BILLINGTON AND LANGHO PARISH COUNCIL
 25, Washbrook Close, Barrow, Clitheroe, BB7 9BP.
 Tel: - 01254 824782

13th February 2012

3/2011/1032 – Proposed log cabin style holiday lodges at Whins Lodge, Whalley old road Langho.

Suggested Typical Plans & Elevations of Lodges @ 1:100

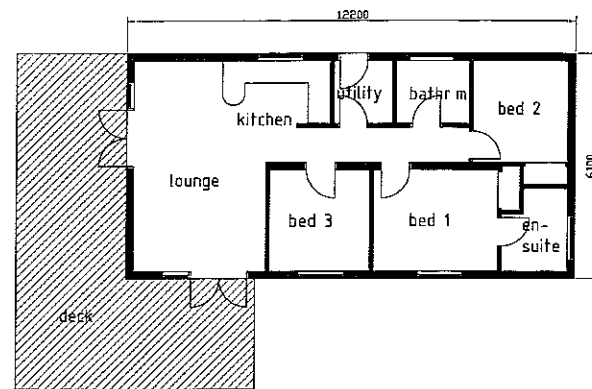
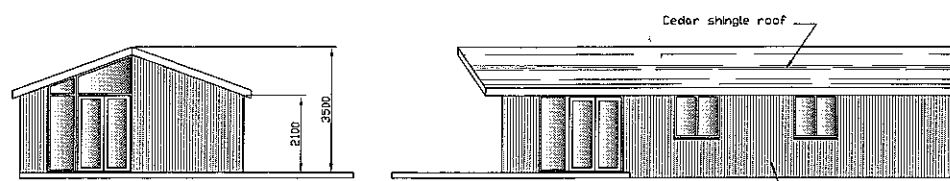
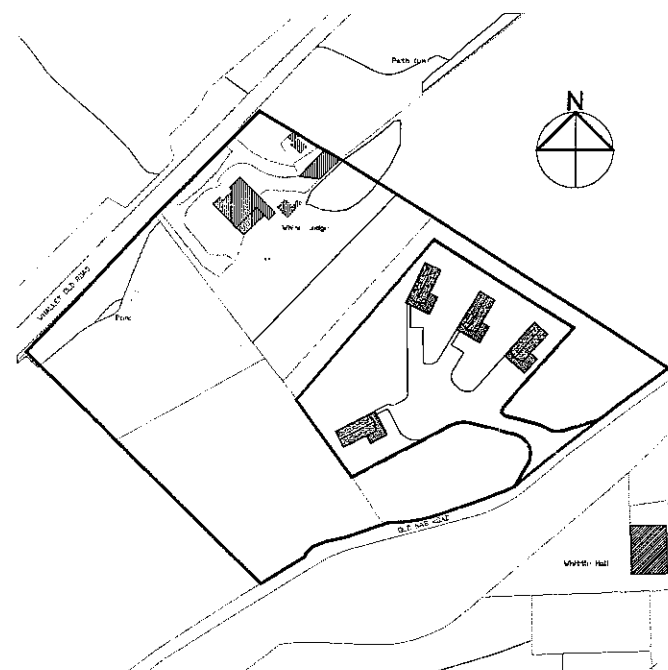
2. We are concerned about the visual impact this development will have.
3. We are concerned about the volume of traffic on a very narrow country road.
4. The official wording does not stipulate the number of lodges to be built although the diagram submitted shows four, therefore we are concerned about a possible escalation in the number of lodges to be built in the future if this outline application is passed.
5. Two letters of objection have also been received from local residents.
